Statement of Common Ground with the Environment Agency ~~(draft)~~

Revision ~~4~~5 (tracked and unsigned)

~~November~~December 2025

- 1.1.1 This Statement of Common Ground (hereafter referred to as the 'SoCG') has been prepared to support the Examination of the Development Consent Order (DCO) application (the 'DCO Application') for Peartree Hill Solar Farm (the 'Proposed Development').

Figure 3.6: Indicative Culvert Crossing Points

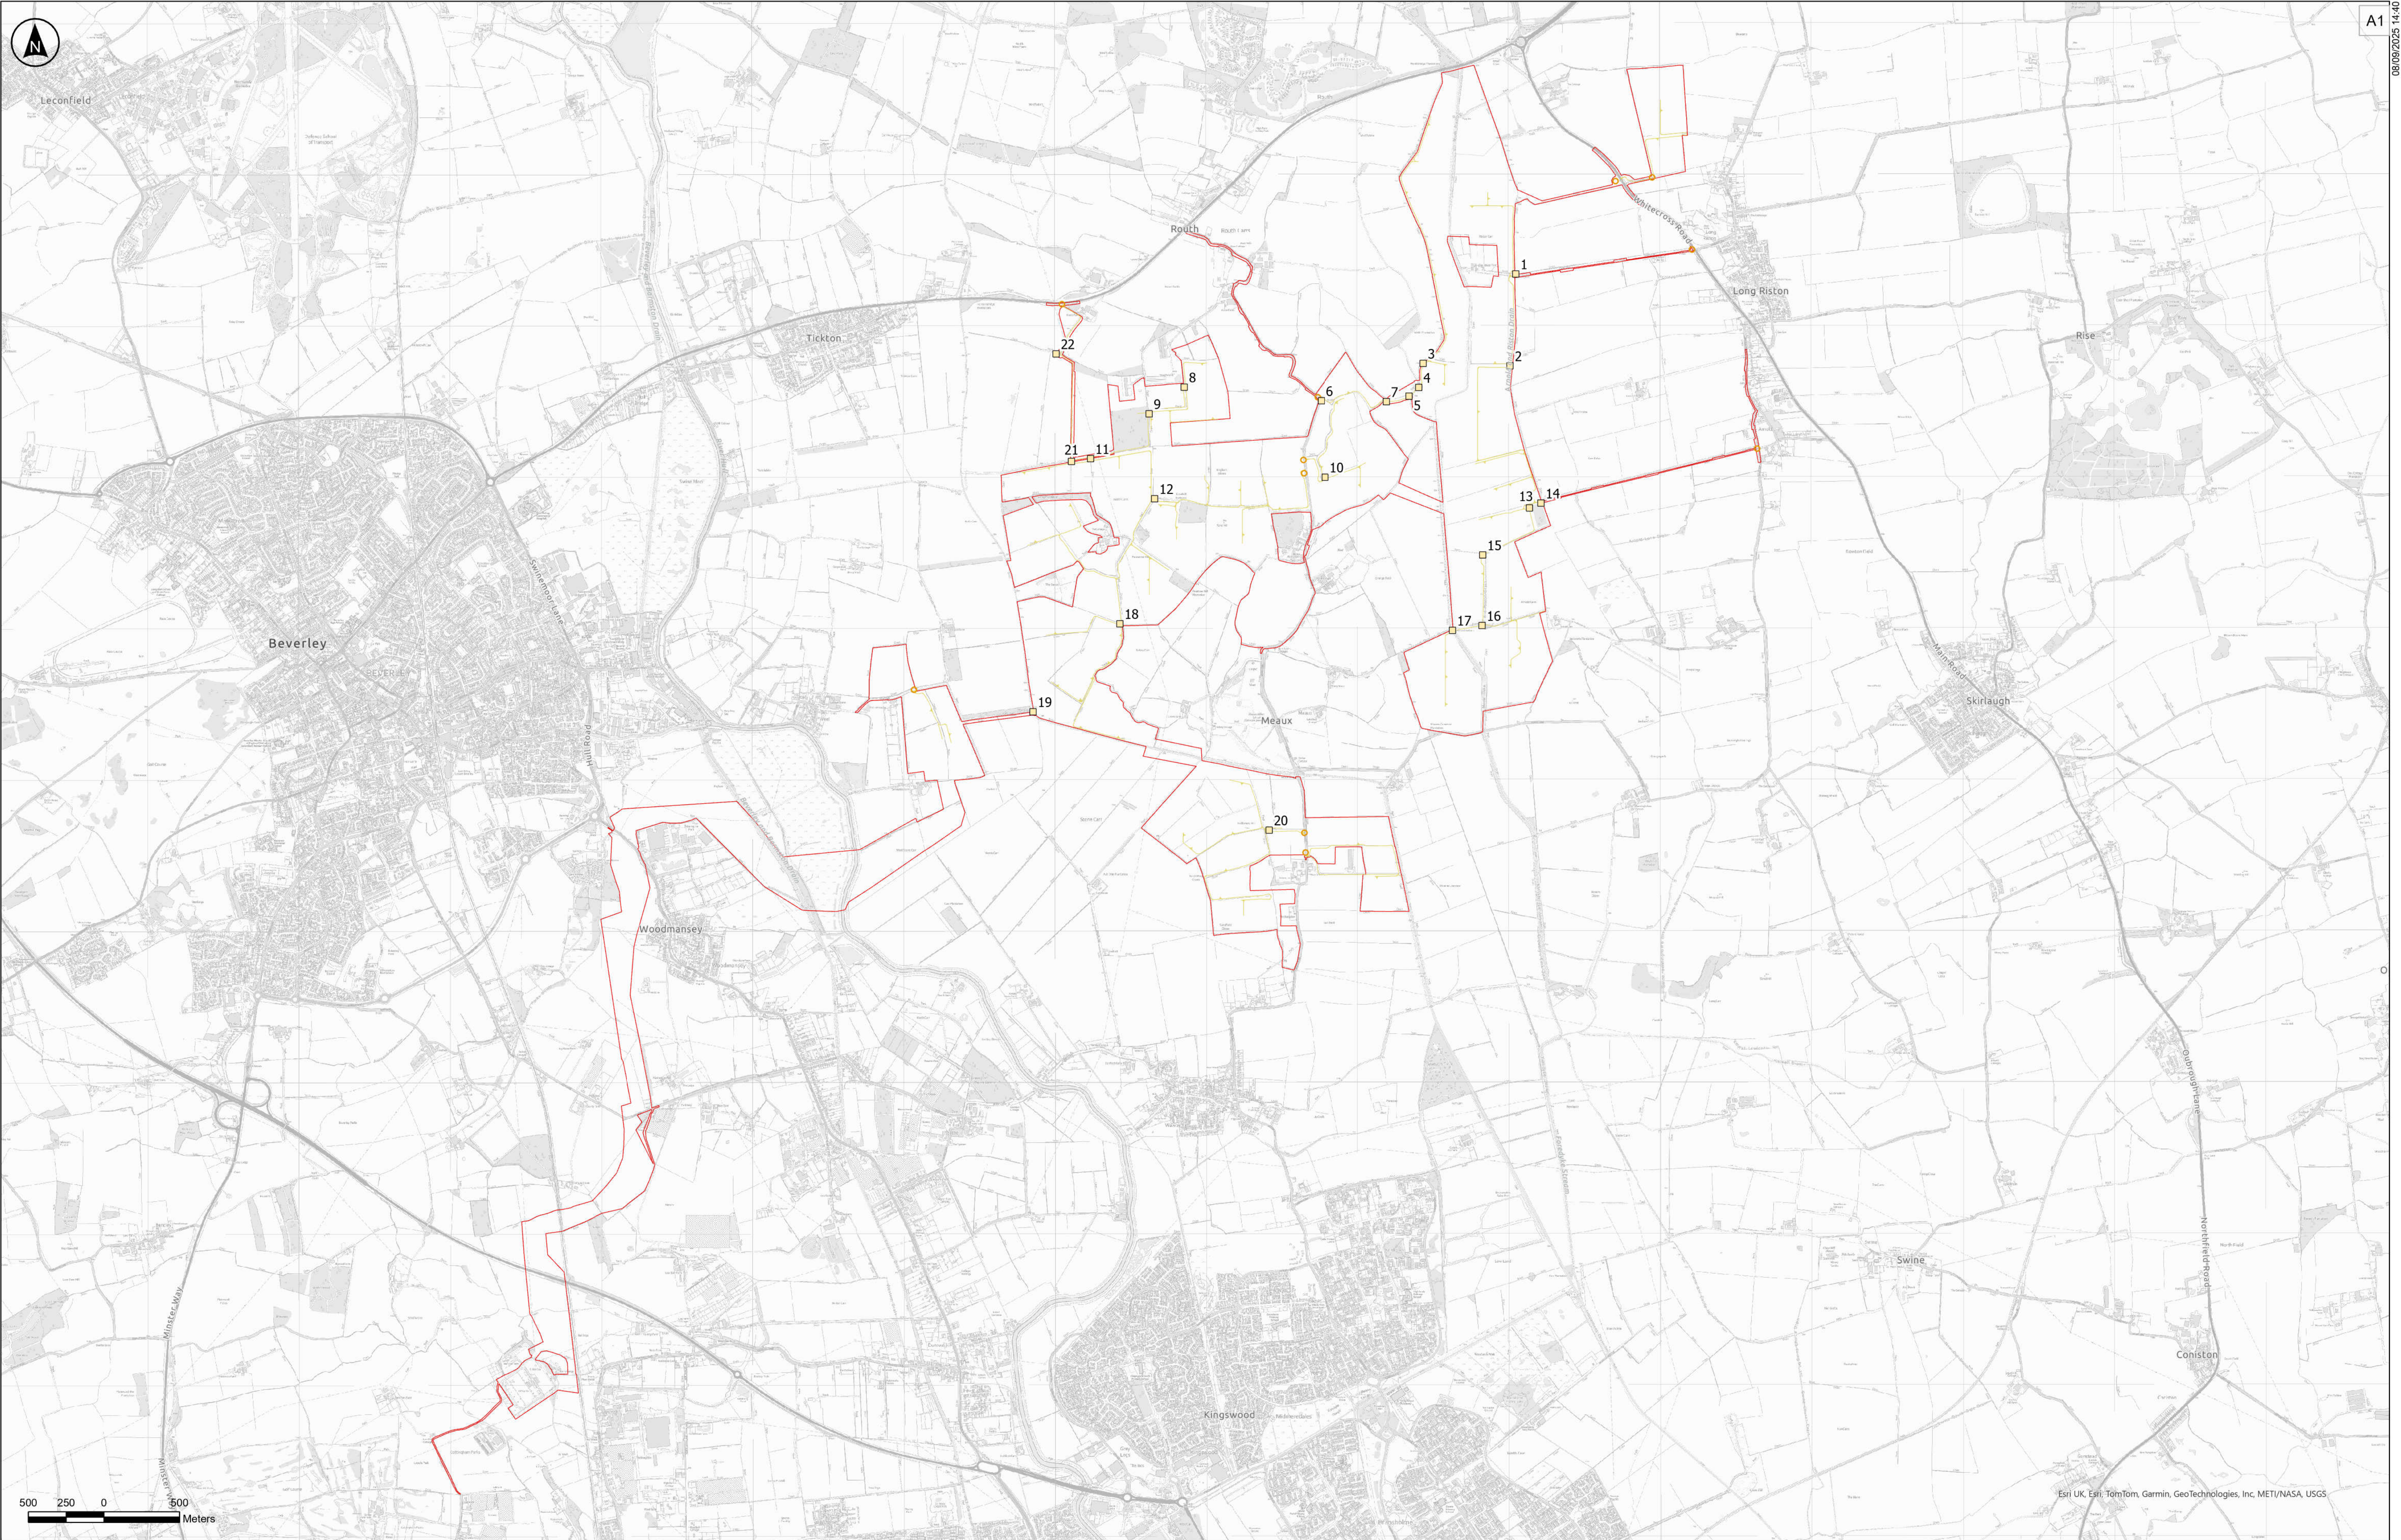
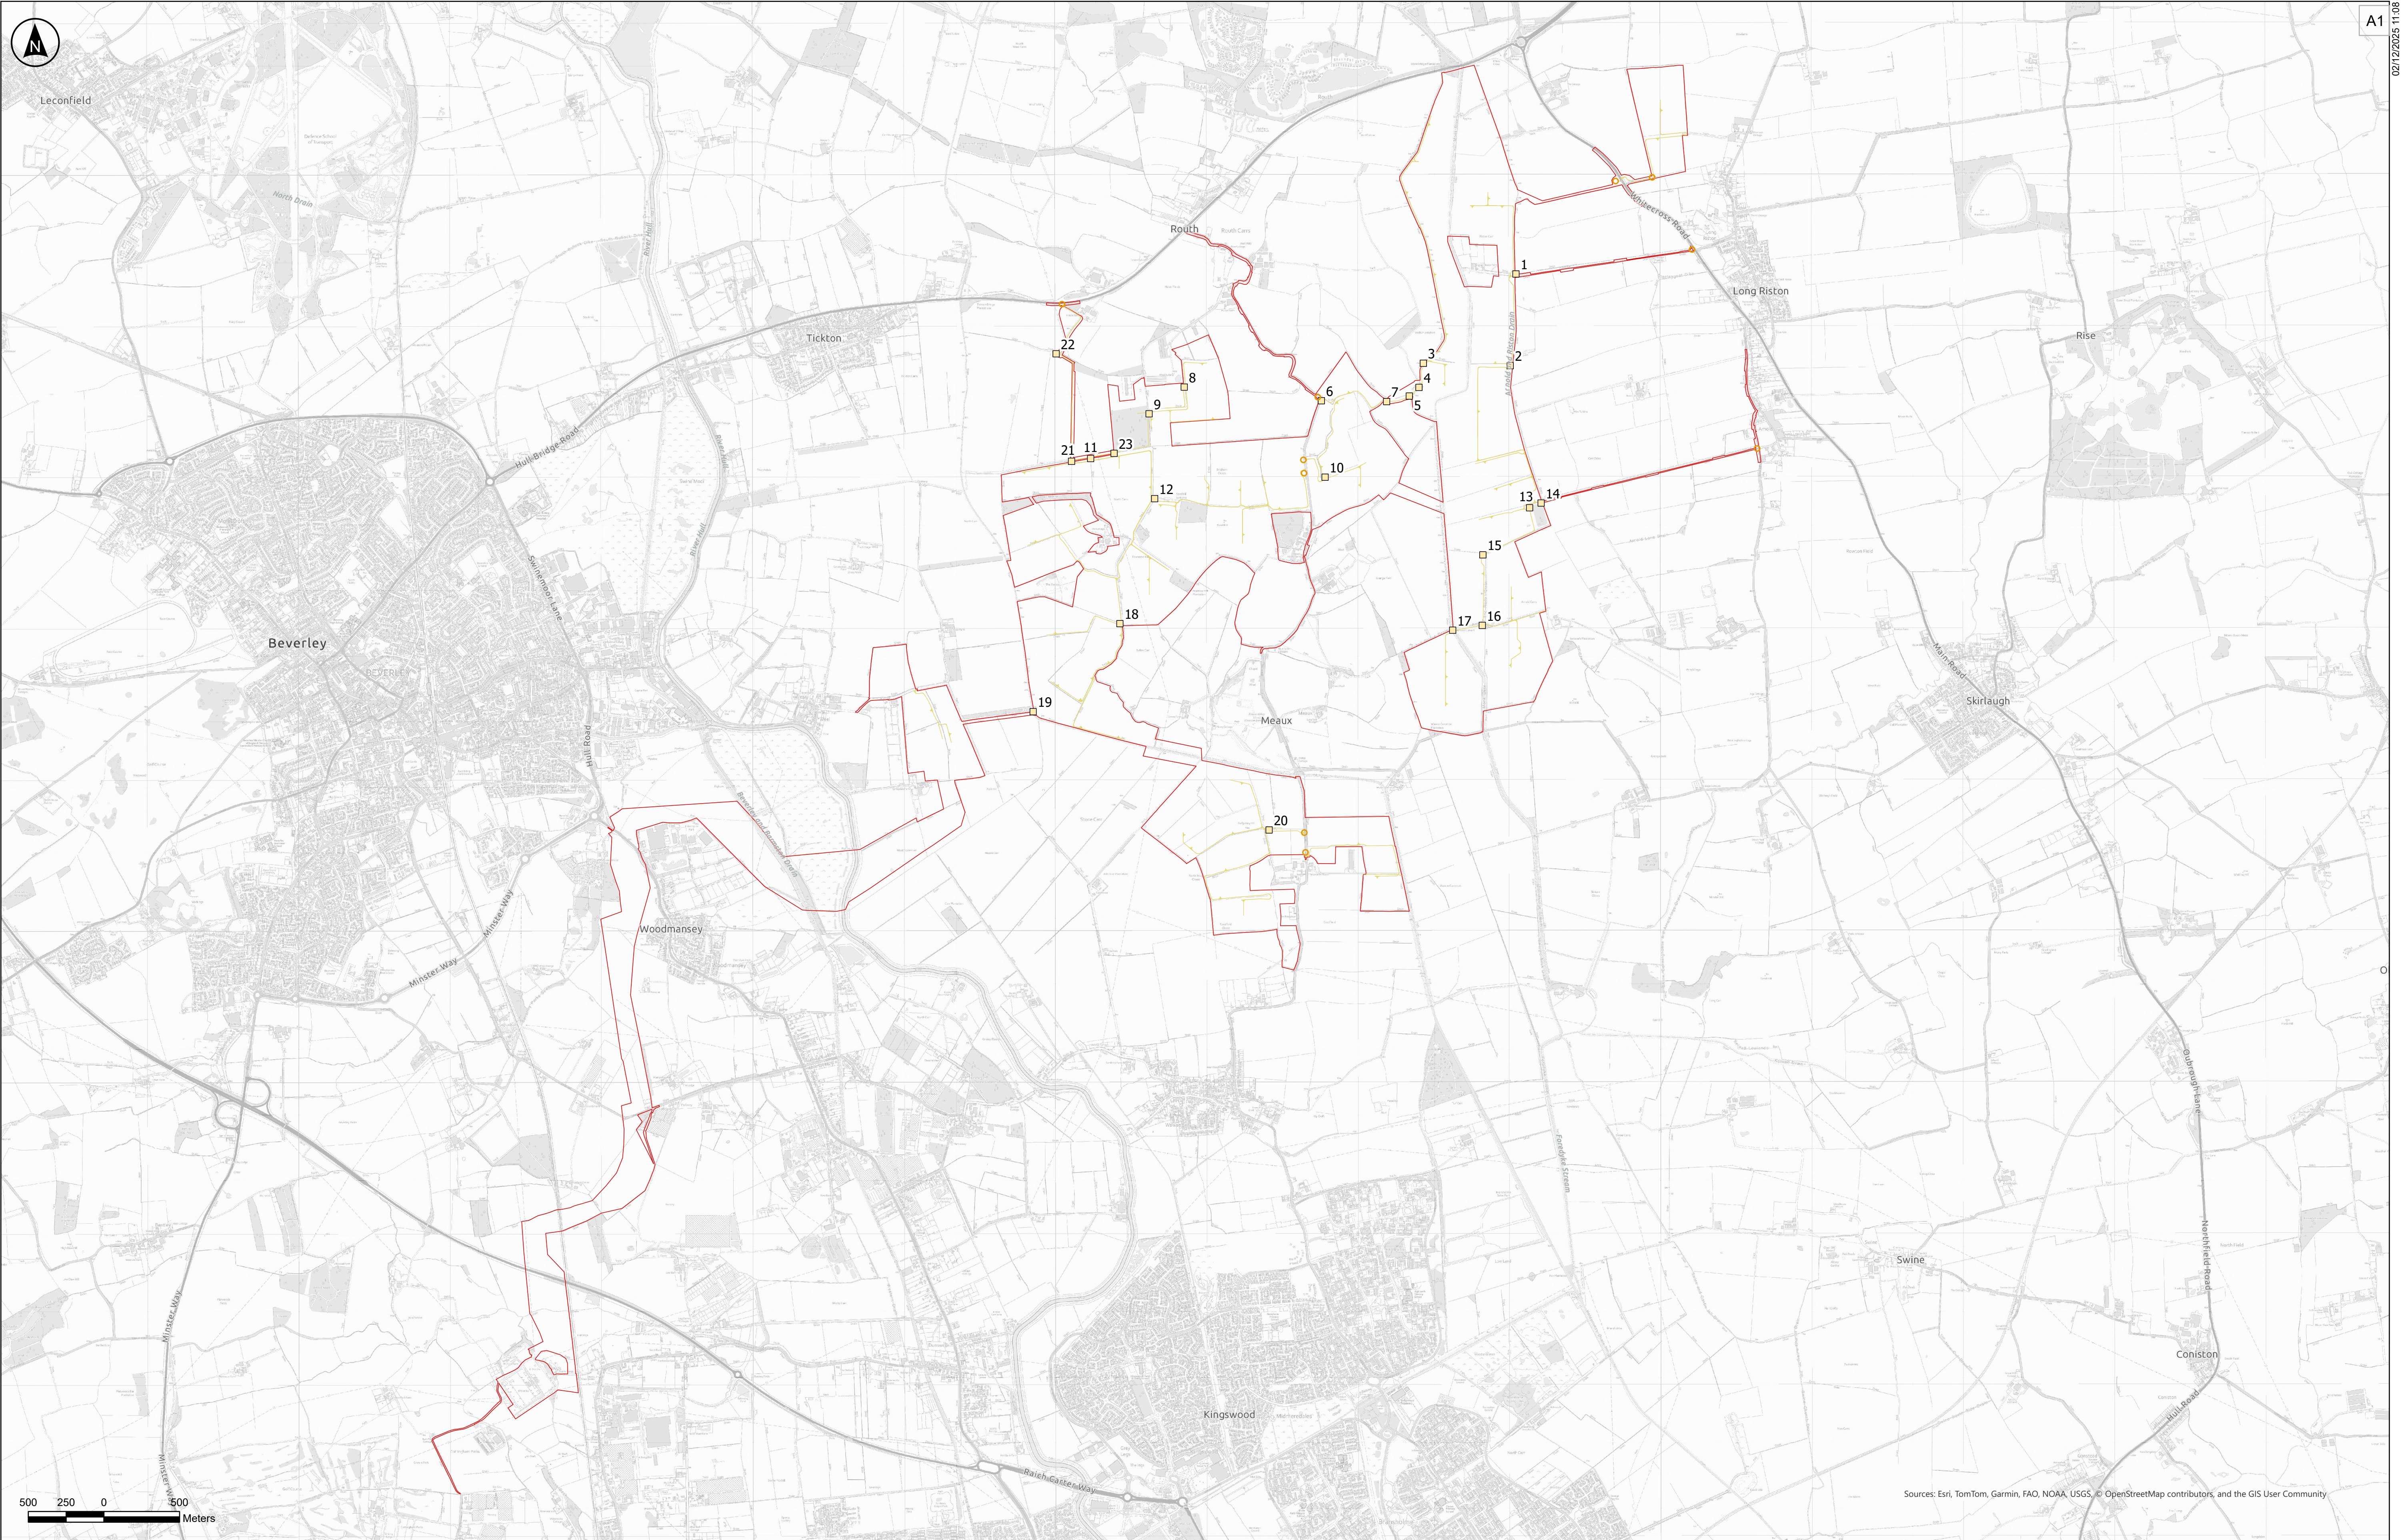
Geomorphology				
EA23	Use of Culverts <i>Hydrology and Flood Risk</i>	In their Comments on the Deadline 1 Submissions [REP2-153] (EA06), the Environment Agency reiterated its request that the Applicant should avoid the use of culverts wherever possible. The Environment Agency welcomes the Applicant's intention to utilise existing culverts or bridges where possible and that for the purposes of the assessment	This response is noted and as per the Applicant's Response to Relevant Representations [REP1-071] , the choice of crossings is subject to detailed surveys and investigations. The preferred method will be agreed with the Environment Agency at the detailed design stage via the Protected Provisions in Part 4 of Schedule 12 to the Draft DCO [EN010157/APP/3.1 Revision 7] . Box culverts were presumed to be utilised for the	Agreed

Ref	Topic	Environment Agency's Position	Applicant's Position	Status
		it has been assumed that all existing crossings will require a new culvert structure. The Environment Agency advises that if any existing box or pipe culvert crossings are found to be unsuitable, they should be upgraded to a portal/3-sided/arch culvert or to a larger box culvert with mammal ledge and be of a size that does not restrict the passage of water. There should be robust (geomorphic) reasons for the use of piped/box culverts. The Environment Agency reiterates that all crossings should be considered on a case-by-case basis following surveys, not just of structural strength, but of habitat and conservation value, including geomorphological activity. In addition, the Environment Agency notes that the cumulative impact of potentially culverting rivers in multiple locations should be considered.	purposes of the assessments (such as ES Volume 4, Appendix 5.5: Water Framework Directive Screening and Scoping [REP1-030]) to follow a precautionary approach. It is the Applicant's intention to utilise existing culvert crossings and/or bridge structures where possible. For the purposes of the assessment, 22 crossings are proposed (see ES Volume 3, Figure 3.6: Indicative Culvert Crossing Points [REP2-093]). Of these, only two locations would require new crossings, which is assessed as having an insignificant impact on watercourse morphology, flows, sedimentation and movement of wildlife. These are assumed to require either the installation of a span bridge or culvert. For re-use of existing crossings these would be reinforcement or widening of the existing culvert/bridge structure. New crossings over minor watercourses, which are likely to be wet for much of the year, would be facilitated by box culverts. These would be fitted with a mammal shelf and the bed substrate would match that of the watercourse within the vicinity of the crossing.

Ref	Topic	Environment Agency's Position	Applicant's Position	Status
		The Environment Agency indicated via email on 16 October 2025 that it anticipates this matter can be resolved by the end of the examination.	The Environment Agency confirmed on the 20 th November 2025 that the above approach is acceptable. Nonetheless , the Applicant will liaise with the Environment Agency on this matter at the detailed design stage.	
EA24	Culverts – Post Decommissioning <i>Hydrology and Flood Risk</i>	In their Comments on the Deadline 1 Submissions [REP2-153] (EA07), the Environment Agency reiterated its concerns around proposals to potentially leave culverts in-situ after decommissioning. The Environment Agency stated that it would like to see a commitment to remove any crossings that have no further use and that given the potential change in environment at point of decommissioning, the options for removal or leaving them in situ should be considered within the DEMP. The Environment Agency confirmed via email on 16 October 2025 that it is satisfied this point has now been addressed via the inclusion of a suitable commitment in the Outline DEMP, which is commitment 678 in the Commitments Register.	The Applicant welcomes this response. As set out in the Applicant's Response to Relevant Representations [REP1-071], the choice of crossing type at each proposed crossing location will be subject to detailed surveys and investigations. The preferred method will be agreed with the Environment Agency. For the purposes of the assessments (such as in ES Volume 4, Appendix 5.5: Water Framework Directive Screening and Scoping [REP1-030]), box culverts were assumed to be utilised at each location in order to follow a precautionary approach. The Applicant notes the Environment Agency's request to remove crossings no longer needed. As recommended by the Environment Agency, this would be assessed ahead of decommissioning using the policy and legislative framework, together with the flood risk and water environment baseline data, available at that time. The Outline DEMP [EN010157/APP/7.4	Agreed

Ref	Topic	Environment Agency's Position	Applicant's Position	Status
			Revision 4] has been updated to include a commitment that an environmental risk assessment will be completed prior to the decommissioning phase for watercourse crossings to determine the options for removal or leaving them in situ.	
Environmental Statement (ES) – scoping out factors as standalone chapters				
EA25	Water <i>Approach to EIA</i>	In a letter dated 22 January 2025, the Environment Agency agreed that Water could be scoped out as a chapter in the ES on the basis that the Flood Risk Assessment and Water Framework Directive Screening and Scoping Report would be submitted with the DCO application; groundwater impacts would continue to be scoped in via the Land, Soil and Groundwater ES chapter; and any remaining issues would be addressed through the DCO Examination.	The Applicant welcomes this response. Please see ES Volume 2, Chapter 5: Approach to the EIA [APP-041] , ES Volume 2, Chapter 10: Land, Soil and Groundwater [APP-046] , ES Volume 4, Appendix 5.5: Water Framework Directive Screening and Scoping Report [EN010157/APP/6.4 Revision 2] and ES Volume 4, Appendix 5.6: Flood Risk Assessment [EN010157/APP/6.4 Revision 3] for details.	Agreed
